### VISTA WEST PERFORMANCE BASED CLUSTER PLAT

TO: Kittitas County Hearing Examiner  
FROM: Kittitas County Community Development Services Staff  
RE: Vista West Performance Based Cluster Plat (CL-09-01)  
DATE: May 26, 2011 Hearing

Requested Action: Fortune Creek LLC, property owner, have applied for a 10-lot performance based cluster plat on approximately 21.09 acres of land that is zoned Rural-3. The project is proposed to be served by a Group B water system and individual on-site septic systems.

VISTA WEST
PERFORMANCE BASED CLUSTER PLAT
A PTN. OF THE NORTH 1/2 OF SEC. 33, T.20N., R.14E., W.M.
KITITAS COUNTY, WASHINGTON

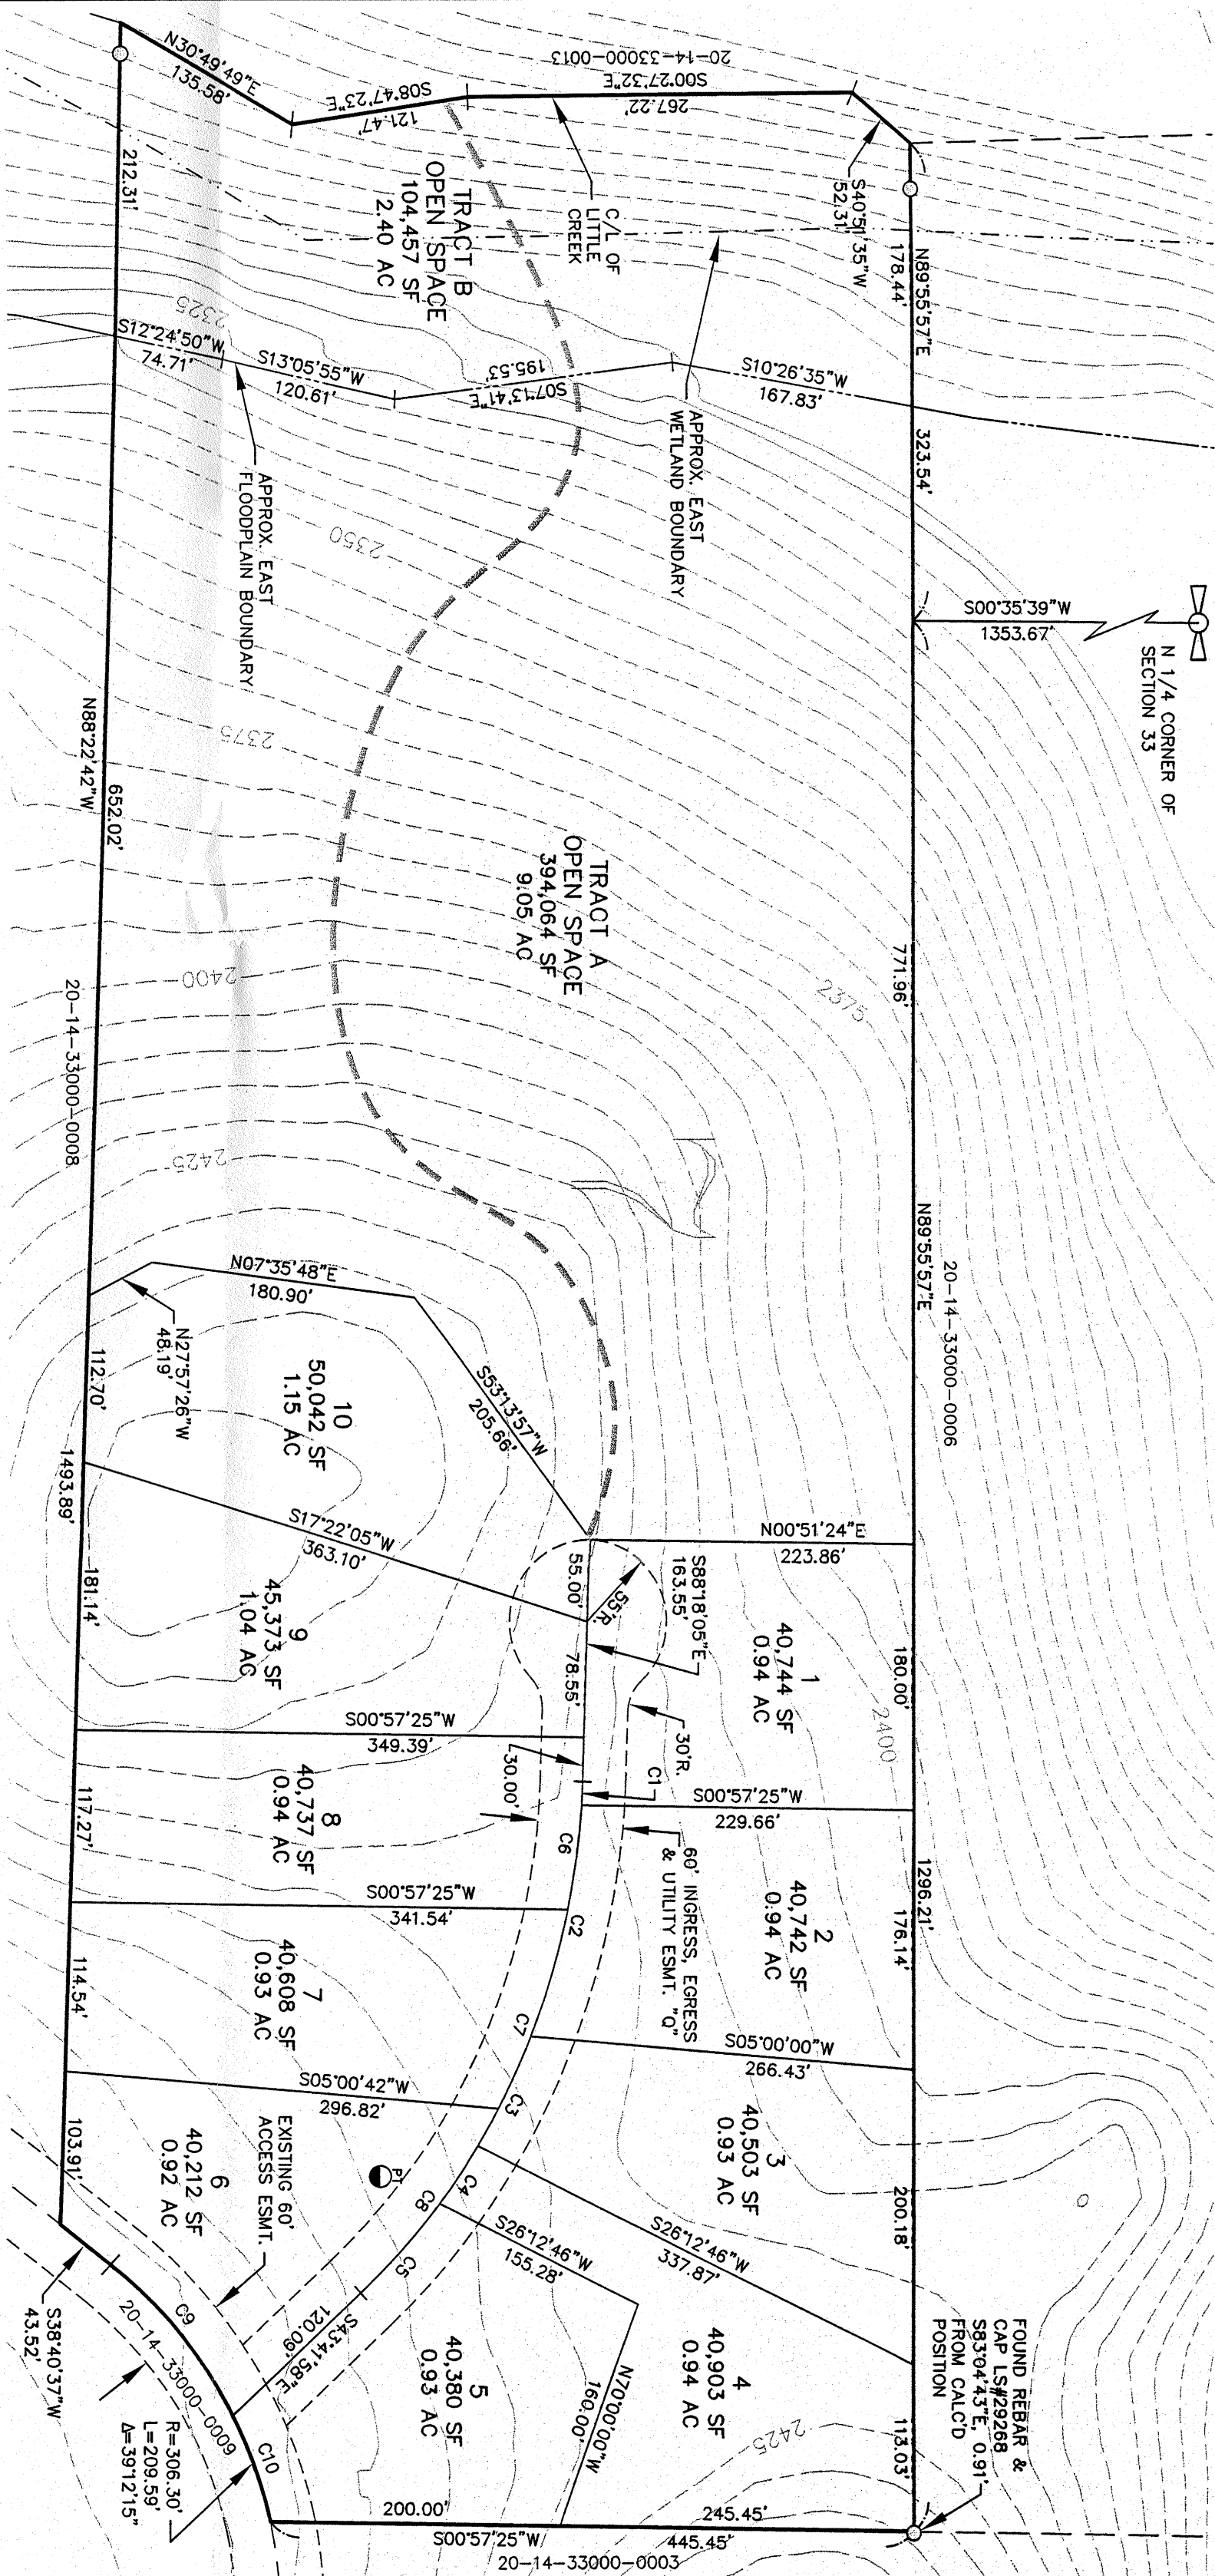
6. Wetland Impacts: The proposed plat area contains a wetland area along Little Creek. No development is proposed in this mapped wetland or within approximately 600 feet. The plat shows a trail passing through the wetland and across Little Creek, and notes this trail is possible for future construction "at the discretion of the owner." Construction of this trail will require compliance with Title 17A Critical Areas.

7. Flood Prone Areas: The project site contains frequently flooded areas associated with Little Creek, which is under the jurisdiction of the County's Shoreline Master Program. No lots are proposed within the floodplain boundary, but a trail for possible future construction is shown. Any development within floodplain associated with Little Creek is subject to 17A.05.020 "No net loss of floodplain storage" and applicable provisions of the Conservancy environment included in the Shoreline Master Program.

8. Future Trail Construction: The following note shall be placed on the face of the final plat:

*The approval of CL-09-00001 does not authorize construction of the proposed trail system noted as “future construction at the discretion of the owner.” The proposed trail passes through a wetland, floodplain, and “Conservancy” shoreline environment. Trail construction shall be subject to County review and approval for compliance with Title 17A Critical Areas and the Shoreline Management Program, and additional wetland and flood storage analysis may be required prior to trail construction.*
